From: Simon Davis
Sent: 15 August 2016 12:57
To: Julia Mills
Subject: FW: EG/57/16/PL - Land adjacent to the Croft Practice
Attachments: 160704 Application Letter 1.pdf; 5499-114-Rev A Elevations.pdf

From: Simon Davis <Simon.Davis@arun.gov.uk>
Sent: 28 July 2016 10:02
To: Jonathan Best
Subject: EG/57/16/PL - Land adjacent to the Croft Practice

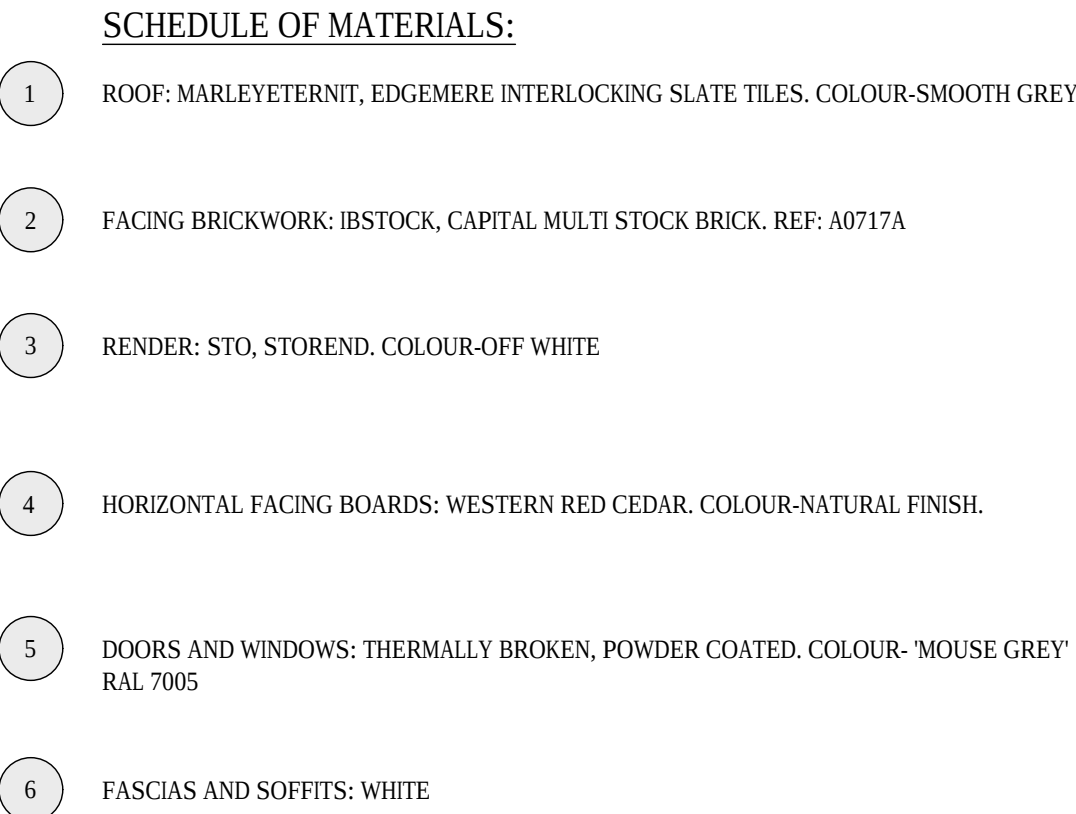
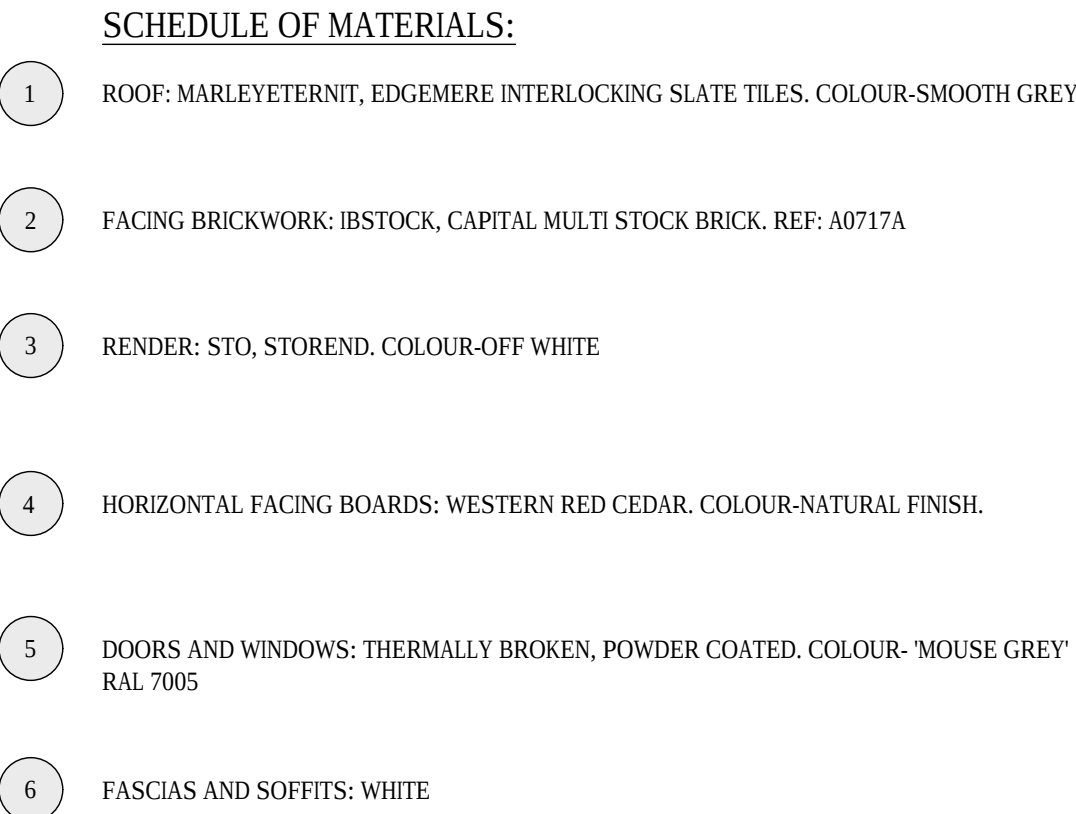
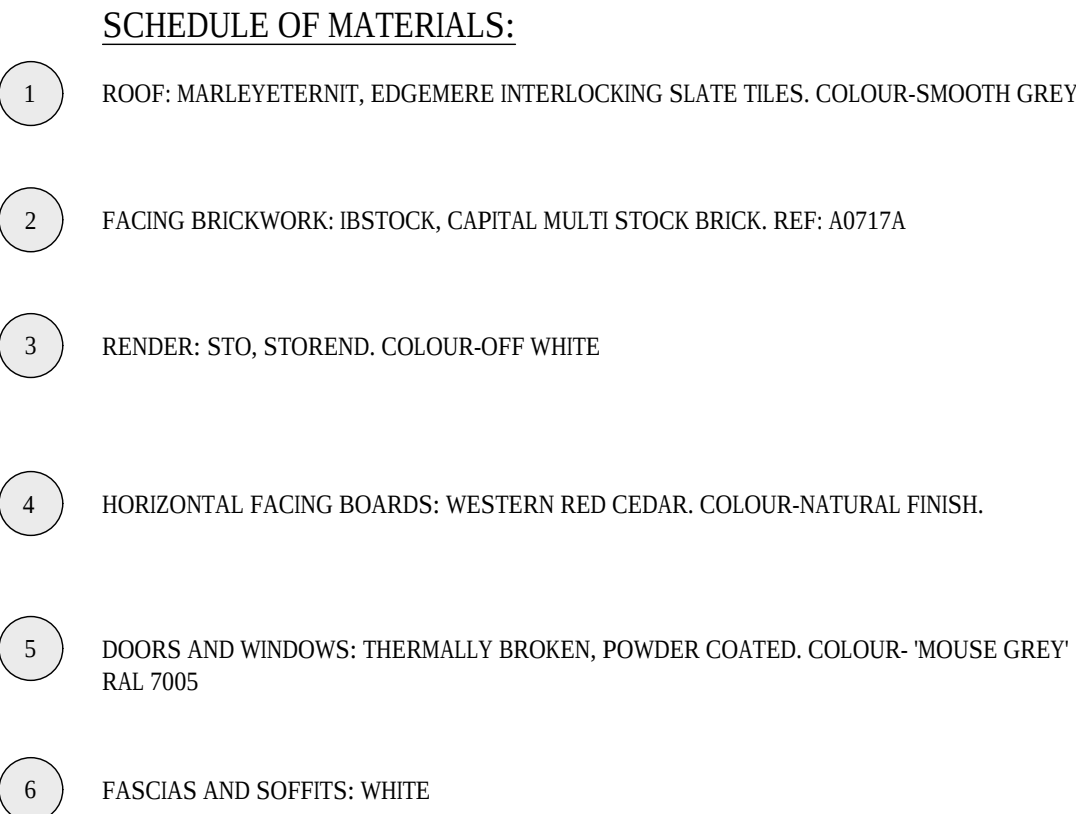
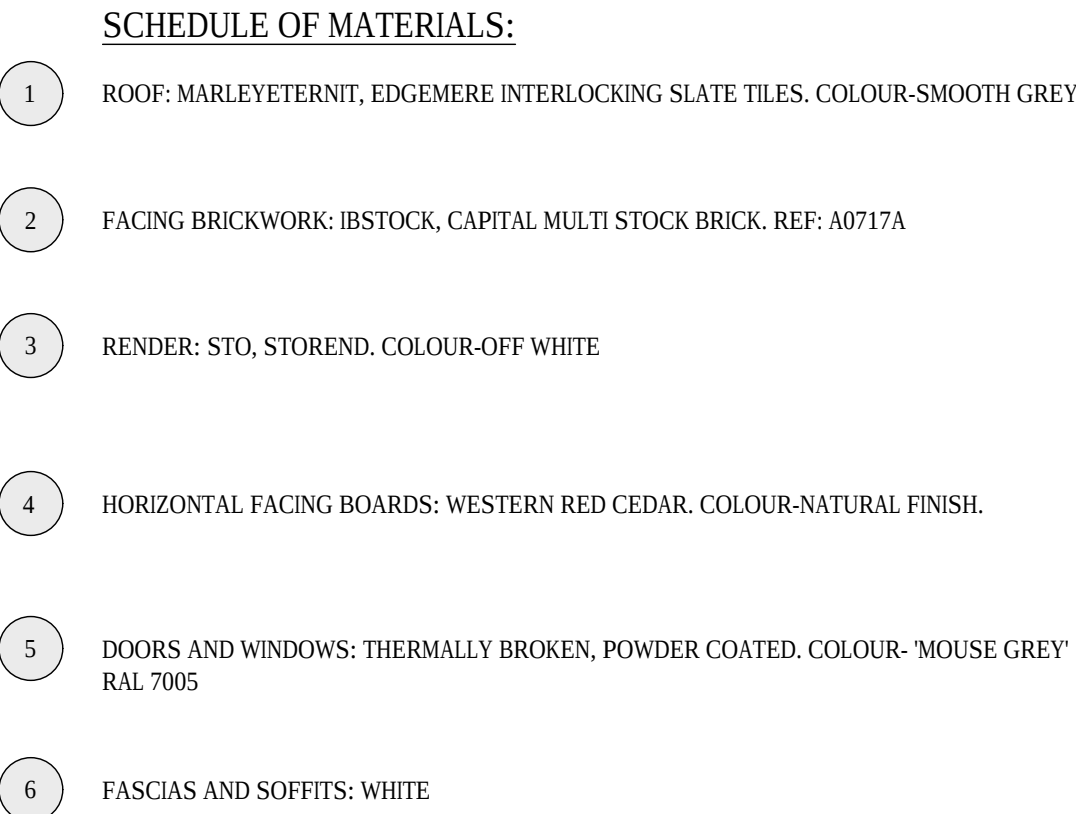
Also I think the Elevations Plan (114) is incorrectly labelled. For example, the site plan shows that the eastern front elevation is around 40m long. But the elevations plan has the eastern elevation as being a side elevation, only 25m long.
